Project Name: * Widening of I-440 from Wade Avenue to Walnut Street

April 23, 2021

Subject: **Request for Modification to the Regional General Permit Number 198200031, Section 401 Water Quality Certification, and Neuse Buffer Authorization for U-2719 – Improve Existing I-440 Beltline, from south of SR 1313 (Walnut Street) to north of SR 1728 (Wade Avenue). Debit WBS 35869.1.2**

PROJECT REFERENCE NO. U-2719	SHEET NO. 14A
RW SHEET NO.	
ROADWAY DESIGN ENGINEER	HYDRAULICS ENGINEER
DOCUMENT NOT CONSIDERED FINAL UNLESS ALL SIGNATURES COMPLETED	
HDR Engineering, Inc. of the Carolinas 555 Fayetteville St. Suite 900 Raleigh, N.C. 27601 N.C.B.E.L.S. License Number: F-0116	
LANE

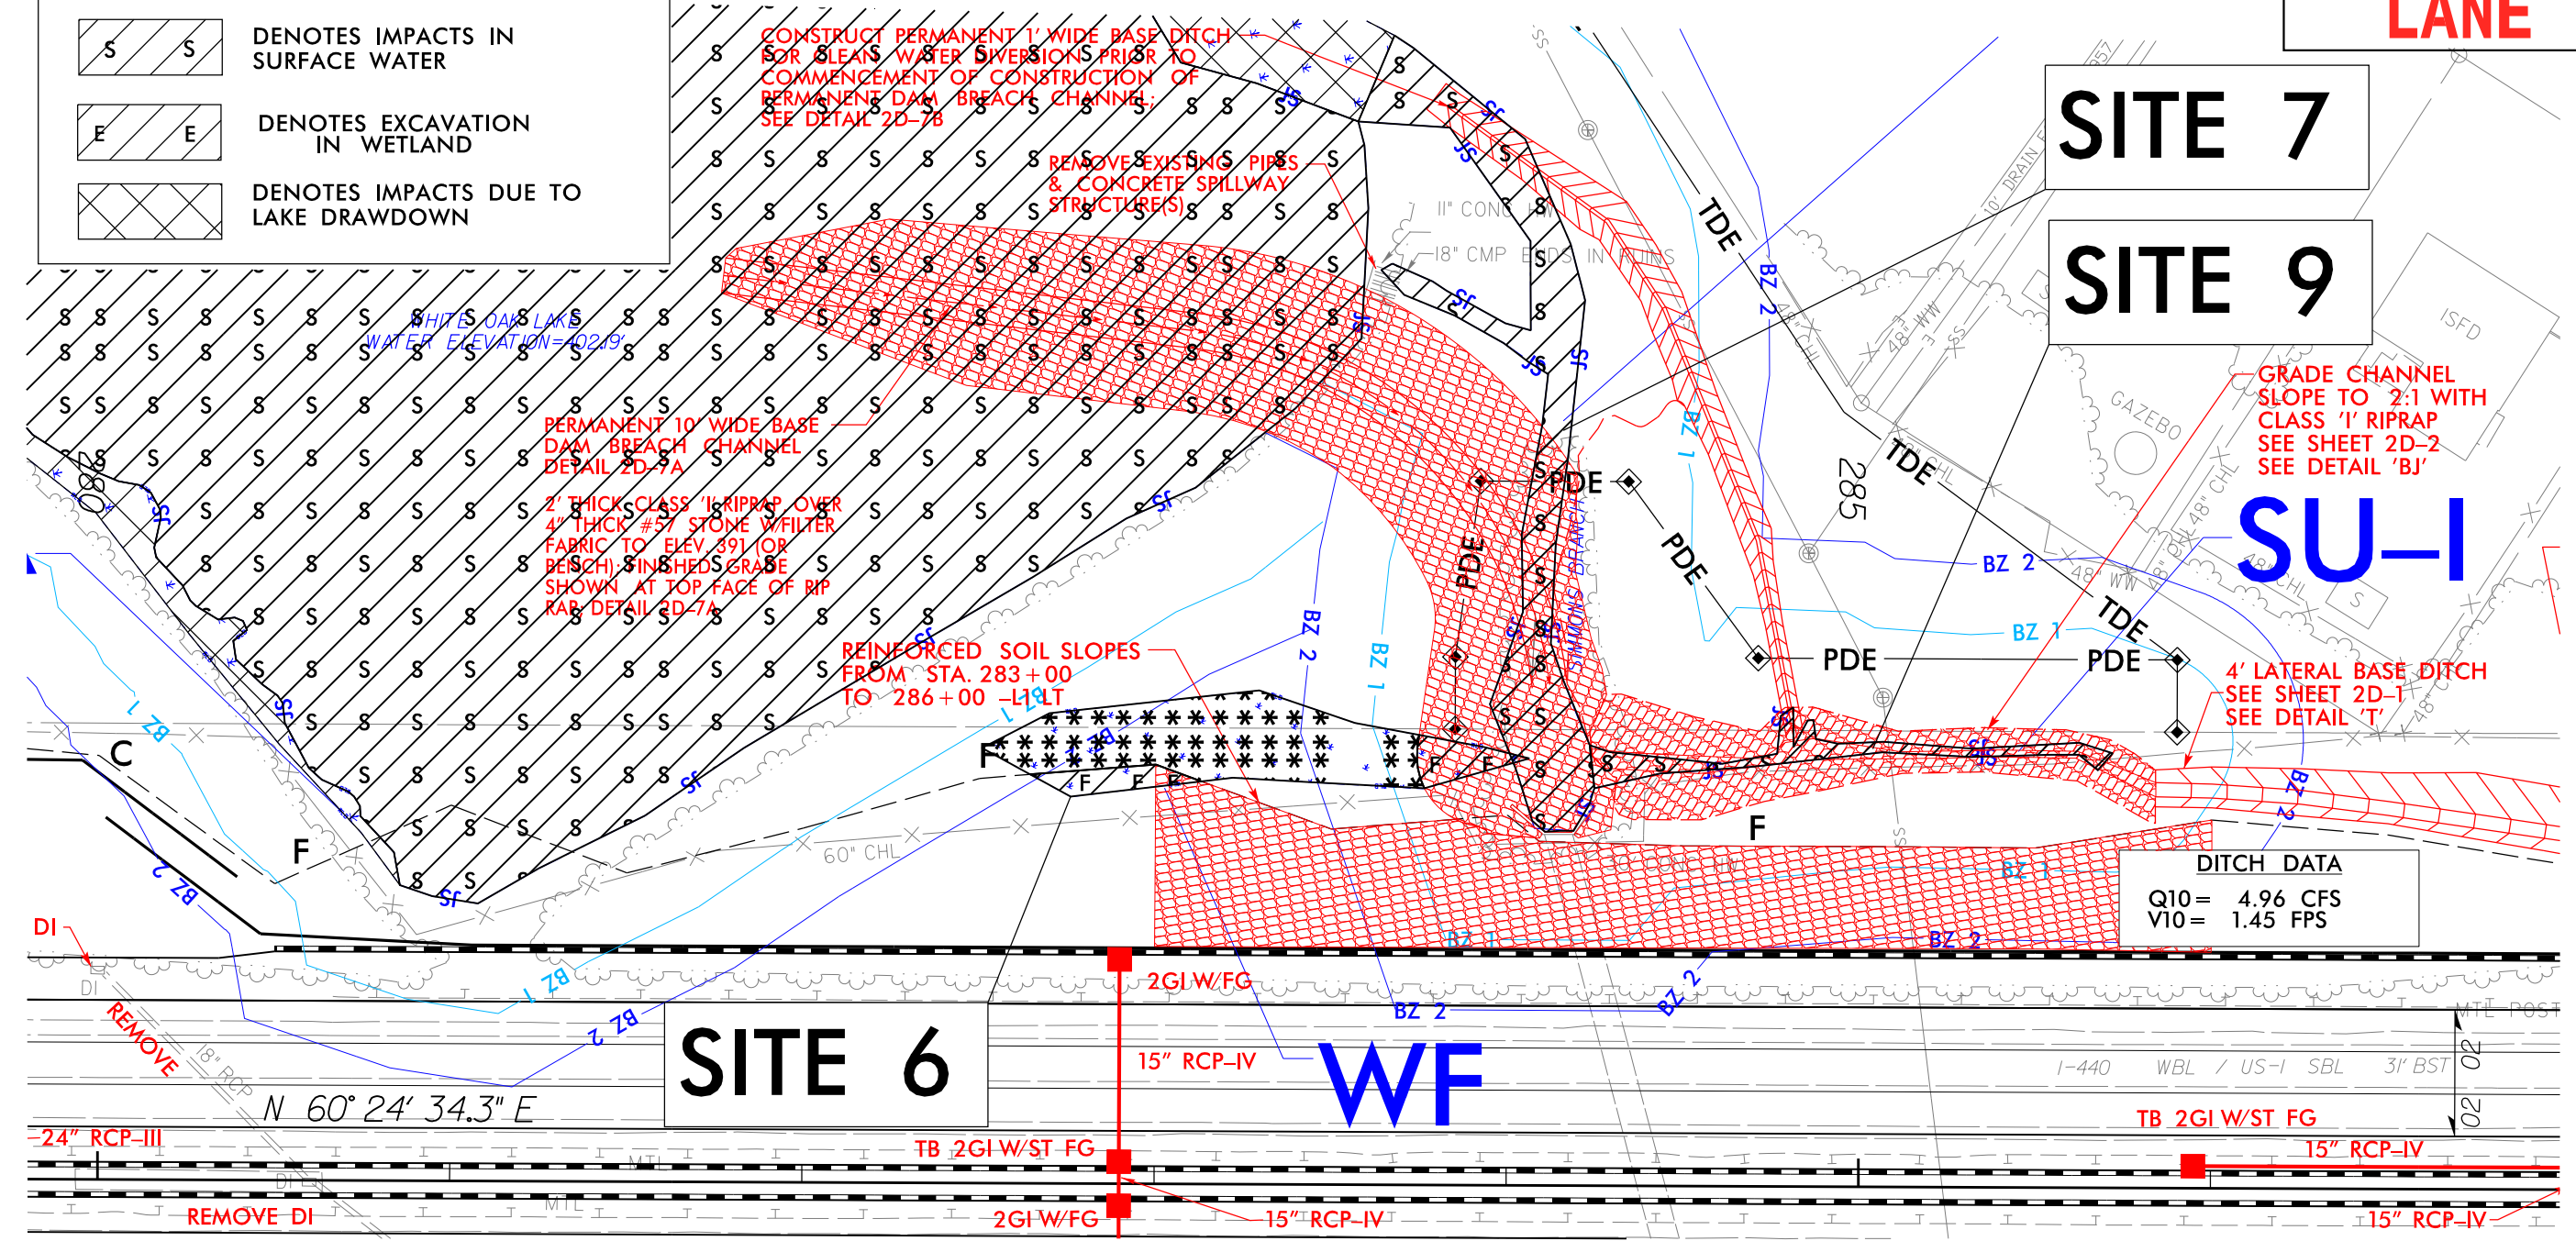
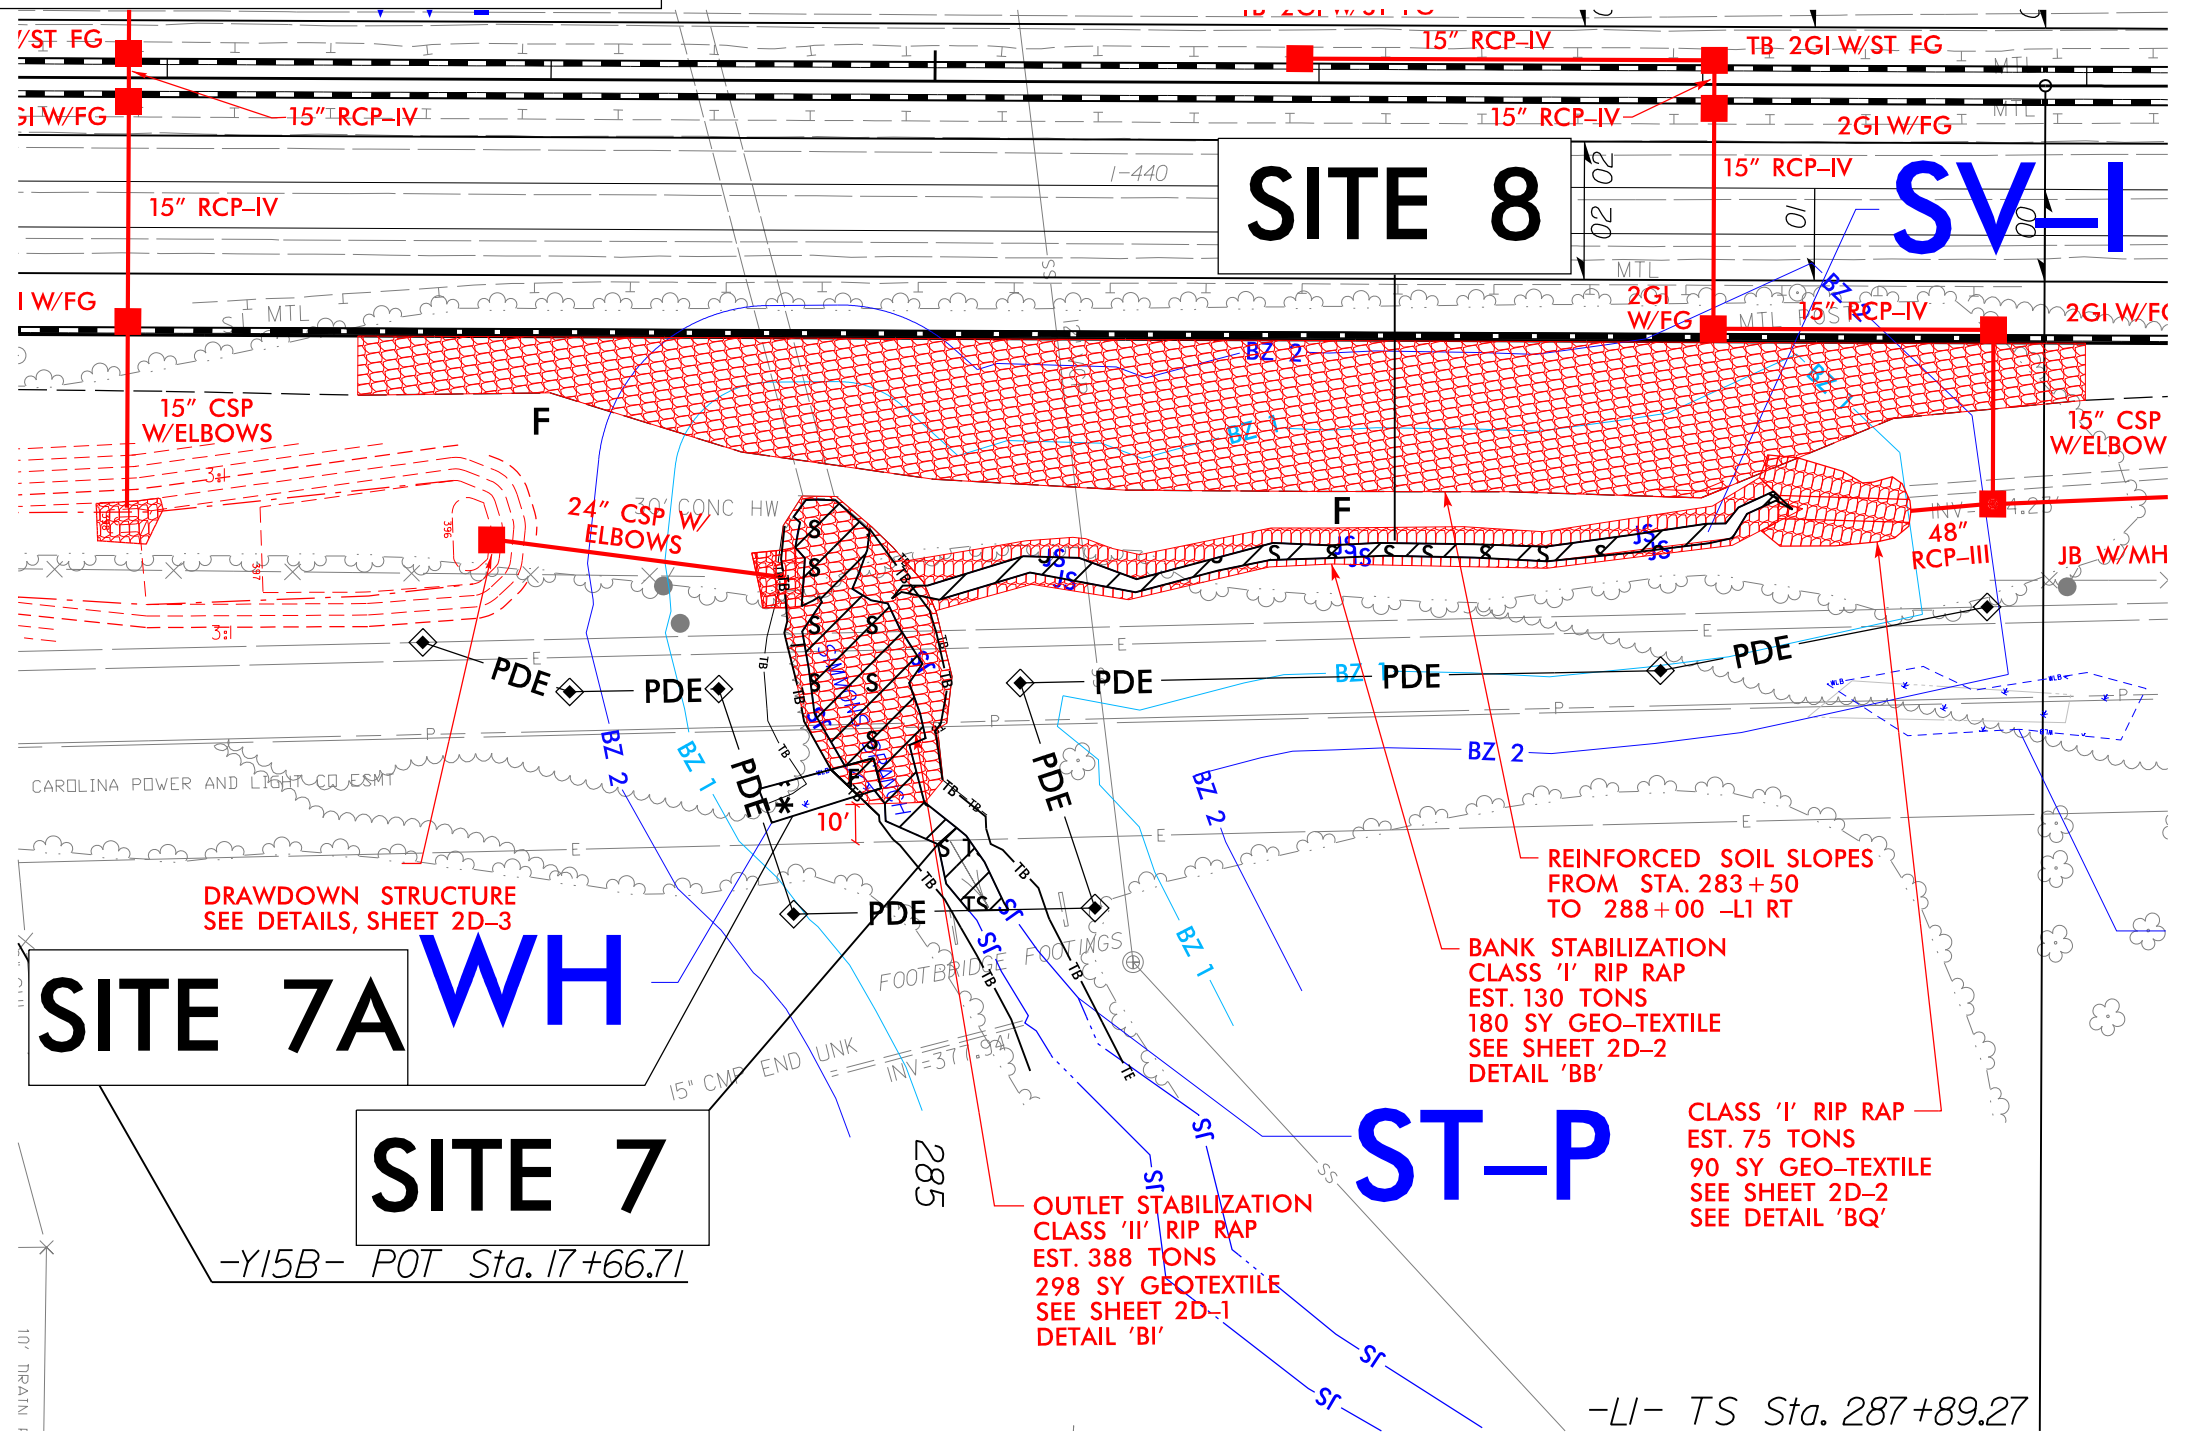
Site 9 (Sheet 14/14A) – Site 9 was slightly different based on the old JD files in the original permit application. This channel has been updated with the new JD files as described above which extends the channel approximately 85 lf. This reach was also previously impacted due to bank stabilization; however, with the changes in design at this location it was determined that the entire channel would require rock armoring to stabilize the area. This is now shown as a permanent fill/stabilization impact on the summary impact table. There is an 85 lf increase in impact due to the new JD file. The new impact is 147 lf which is shown as permanent fill/stabilization impact.

Buffer Site 9 (Sheet 14/14A) – Site 9 buffers have also changed as a result of the new JD file. Site 9 buffer impacts have increased in Zone 1 by 2,708 sq ft to 6,639 sq ft. Zone 2 buffers have increased by 1,392 to 2,738 sq ft. No additional buffer mitigation is proposed for the additional buffers associated with the new JD file, as redesign and impacts are linked to the dam breach impacts which were previously considered non-mitigable by NCDWR.

Site 10 and Site 11 (Sheet 14/14A) – Previous wetland Sites 10 (WJ) and 11 (WI) have been removed due to the most recent JD files discussed above. The area that was previously illustrated as wetland is part of stream SU-I in the revised delineation. This results in a reduction in wetland impact by <0.01 ac of excavation and <0.01 ac of mechanized clearing for Site 10 and <0.01 ac of excavation and <0.01 ac of mechanized clearing for Site 11.

Buffer Site 10 (Sheet 14/14A) – Previously there were no impacts illustrated with the buffers around White Oak Lake due to the City of Raleigh project. The buffer impacts illustrated at Site 10 are associated with construction and access for the dam breach at White Oak Lake. This results in 10,337 sq feet of Zone 1 impacts and 4,597 sq ft of Zone 2 impacts.

Site 22 (Sheet 14/14A/29A) – Site 22 was added to illustrate the open water impacts associated with breaching the dam of White Oak Lake. The open water impact associated with the breach is 5.10 ac. This site also includes impacts to the fringe wetlands around the lake due to the drawdown of the lake. This area has been hatched on the attached plan sheets and the 2.65 ac of wetland fringe has been noted at the bottom of the summary impact table since it does not match any of the wetland impact types illustrated on the summary table.

SITE 7 DOWNSTREAM AND SITE 8 BUFFER IMPACTS REMOVED DUE TO UTILITY EASEMENT MAINTENANCE AND 4C DISCUSSION

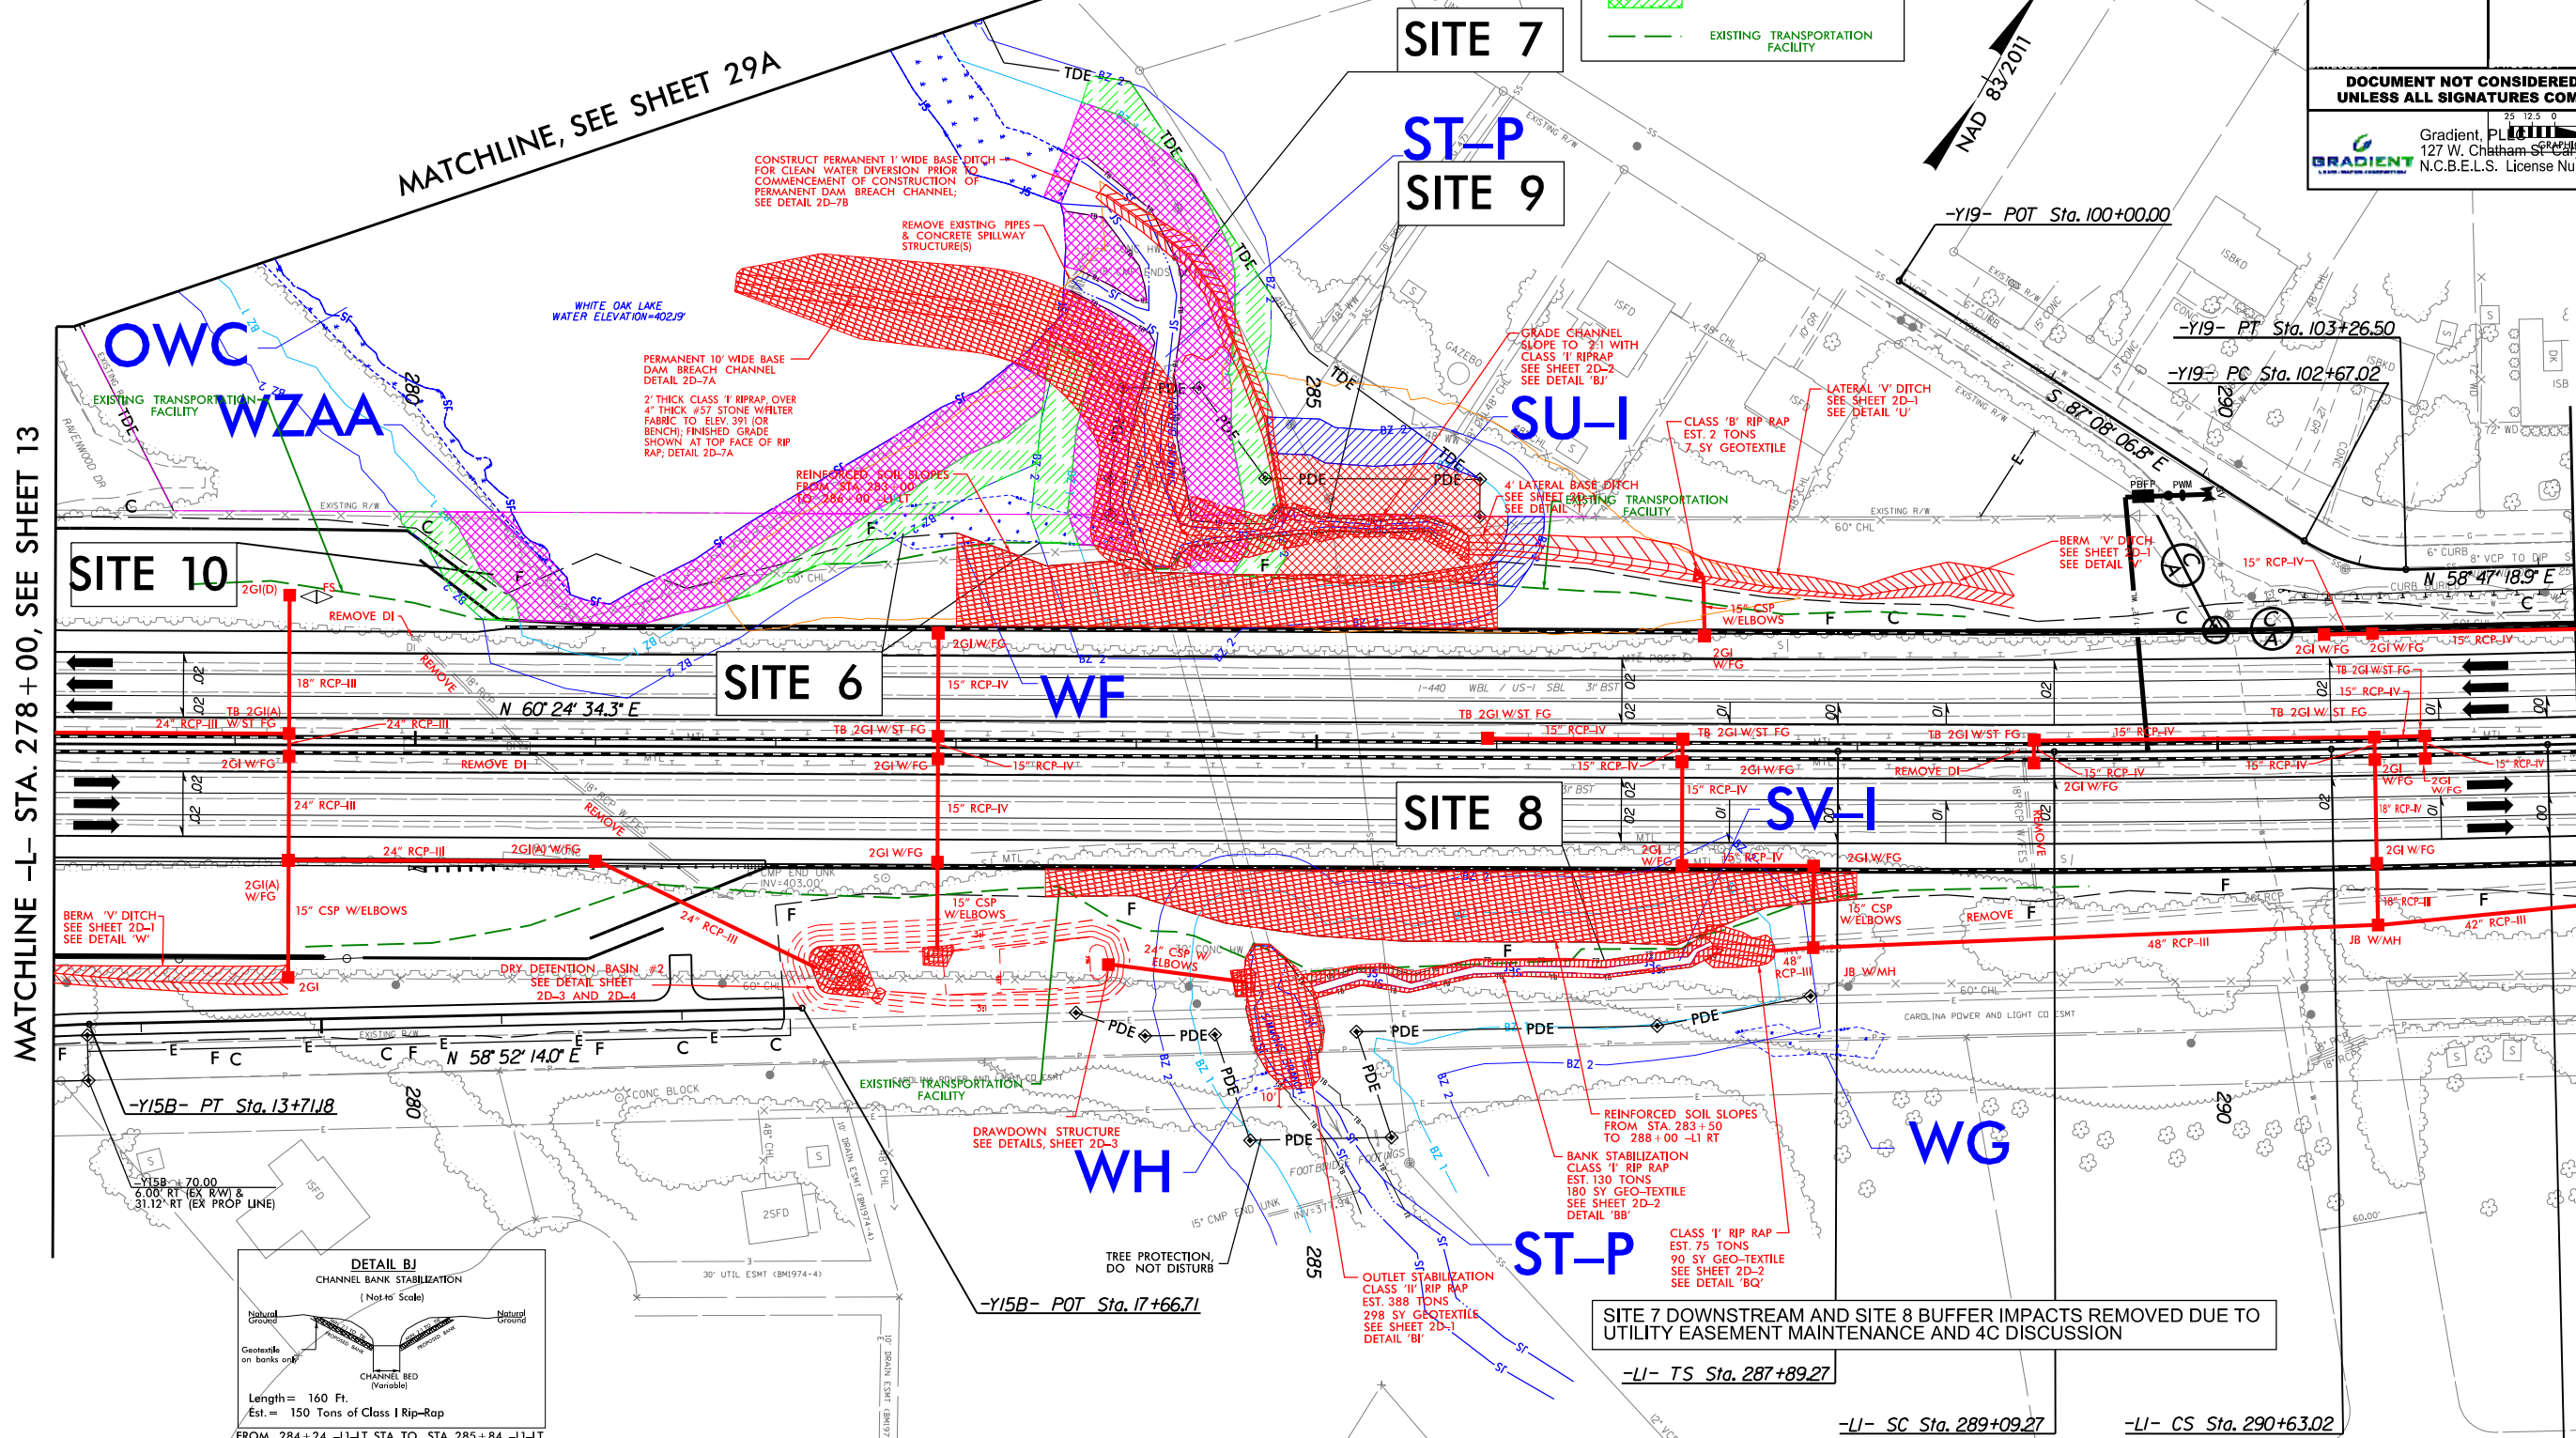
Buffer Site 7 (Sheet 14) – Site 7 buffers have changed as they will now be impacted by the White Oak Lake dam breach and access requirements. The total impact in Zone 1 is 14,399 sq ft and Zone 2 is 6,548 sq ft for Site 7. This is an increase in Zone 1 impact by 12,939 sq ft and 5,677 sq feet in Zone 2. Site 7 buffer impacts on the outlet side were reviewed and it was determined that those have been previously cleared and are no longer illustrated as an impact.
